**WELWYN HATFIELD BOROUGH COUNCIL  
EXECUTIVE DIRECTOR - PLANNING, PUBLIC PROTECTION AND GOVERNANCE**

**DELEGATED APPLICATION**

**Application No:** 6/2020/1972/HOUSE  
**Location:** 99 The Ridgeway Cuffley Potters Bar EN6 4BG  
**Proposal:** Erection of two storey side extension with 2 x dormers to the front and 2 x to rear and new front boundary entrance gates and wall.  
**Officer:** Mr Tom Gabriel

**Recommendation:** Refused

Drawing No: 4996-PLNG-P01 Revision: A

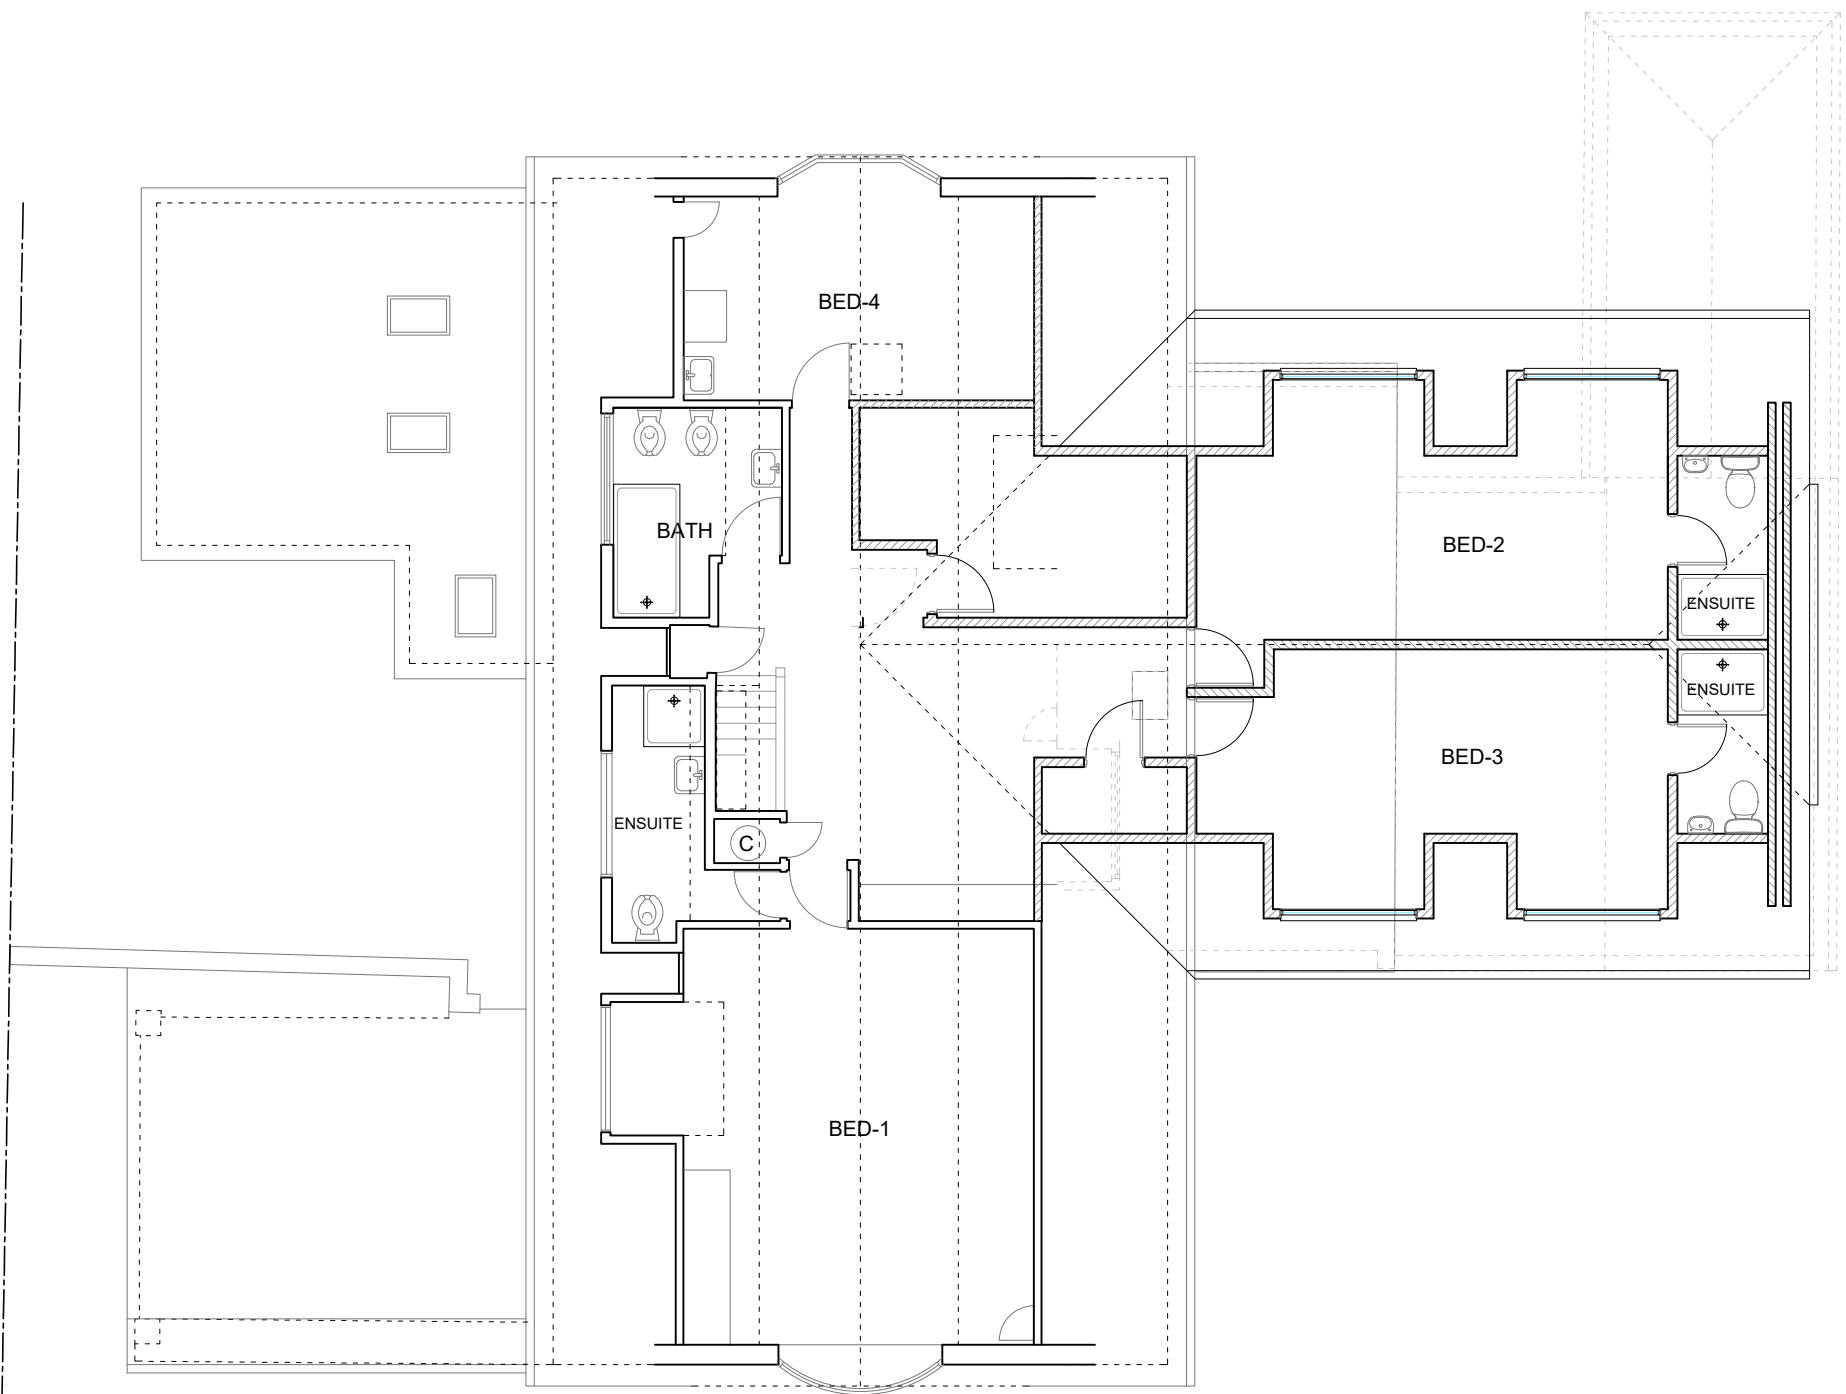
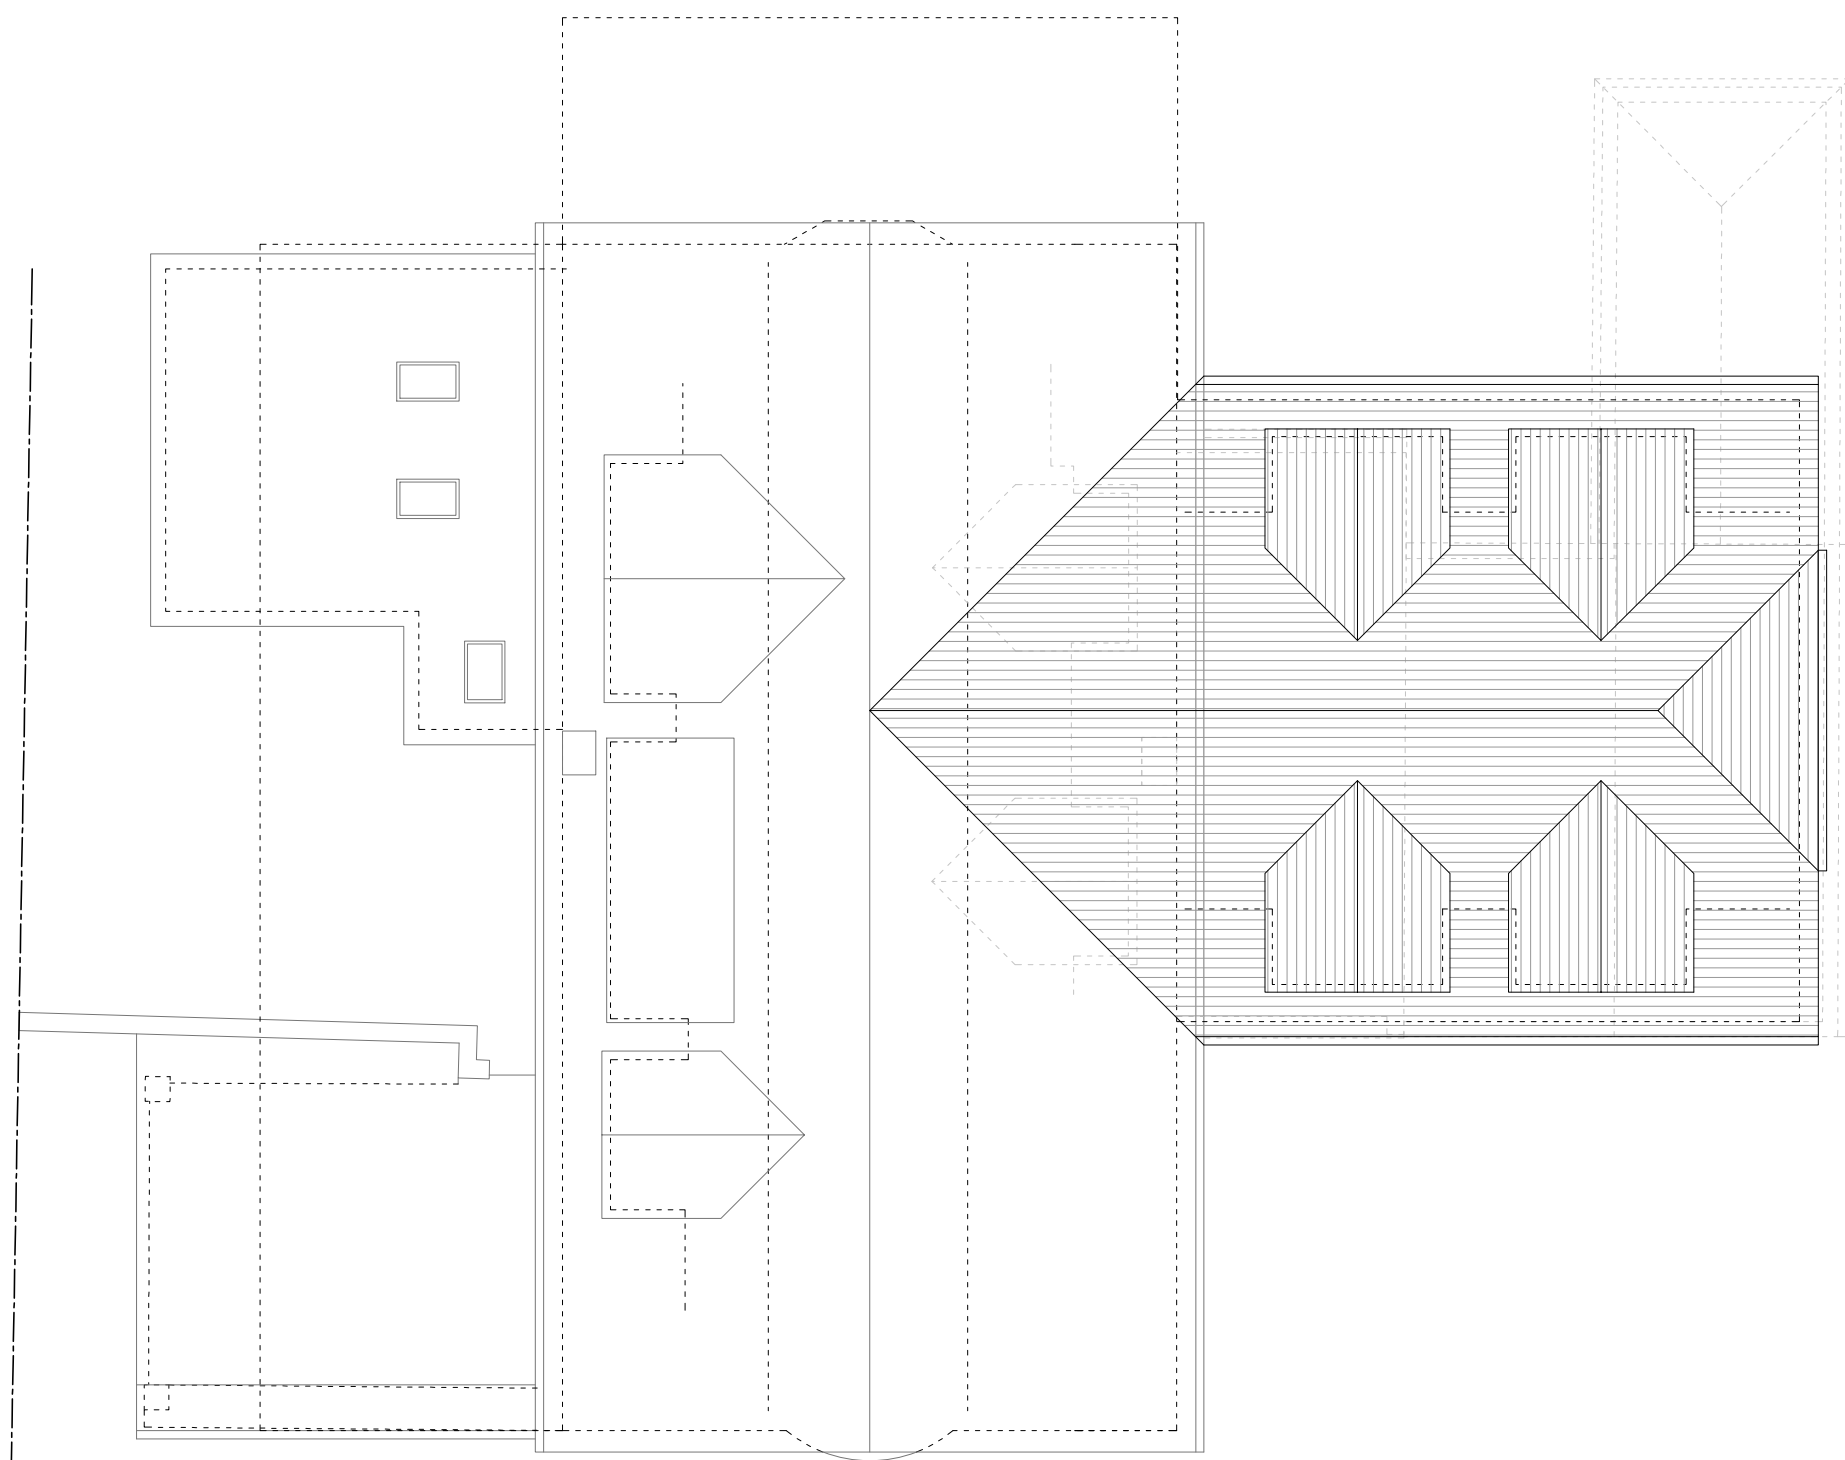
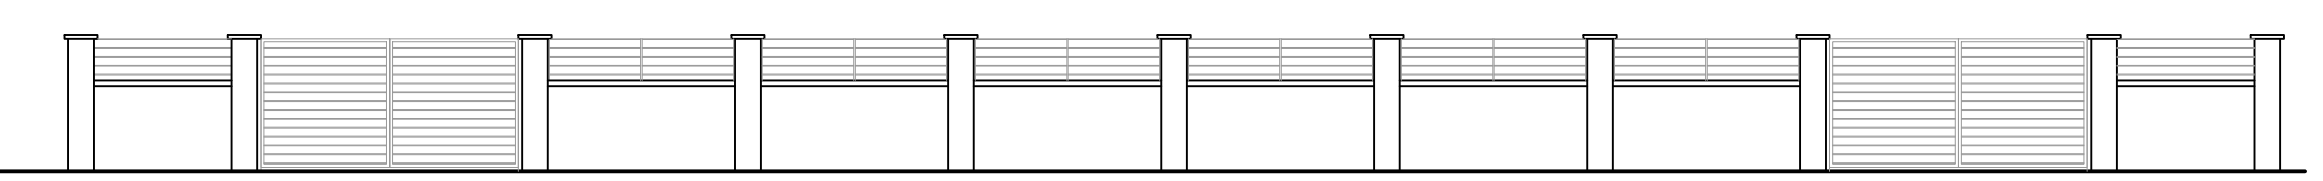
The proposed side extension would significantly reduce the gap between the dwelling and its neighbour and would close down open views between the properties. This visual impact, together with the increased bulk, footprint and massing of the built development, would result in a material loss of the openness and visual permeability of the Green Belt.

The proposal also includes the erection of new front boundary wall and entrance gates. The submitted Block Plan and elevation drawings do not show any existing front boundary features.

1. The proposal represents inappropriate development in the Green Belt and would result in a material loss of Green Belt openness. No very special circumstances exist to clearly outweigh this harm. Consequently, the proposed development would conflict with Policies GBSP1 and RA3 of the Welwyn Hatfield District Plan 2005 and the National Planning Policy Framework.

2. By virtue of their height and extent across the full width of the property and the absence of other similar comparable features in the immediate vicinity of the site, the proposed front boundary treatment and gates would have a harmful impact upon the street scene and would cause harm to the character of the area. The proposed treatment and gates therefore represent a poor standard of design in conflict with Policies D1 and D2 of the Welwyn Hatfield District Plan 2005, Supplementary Design Guidance 2005 and the National Planning Policy Framework.
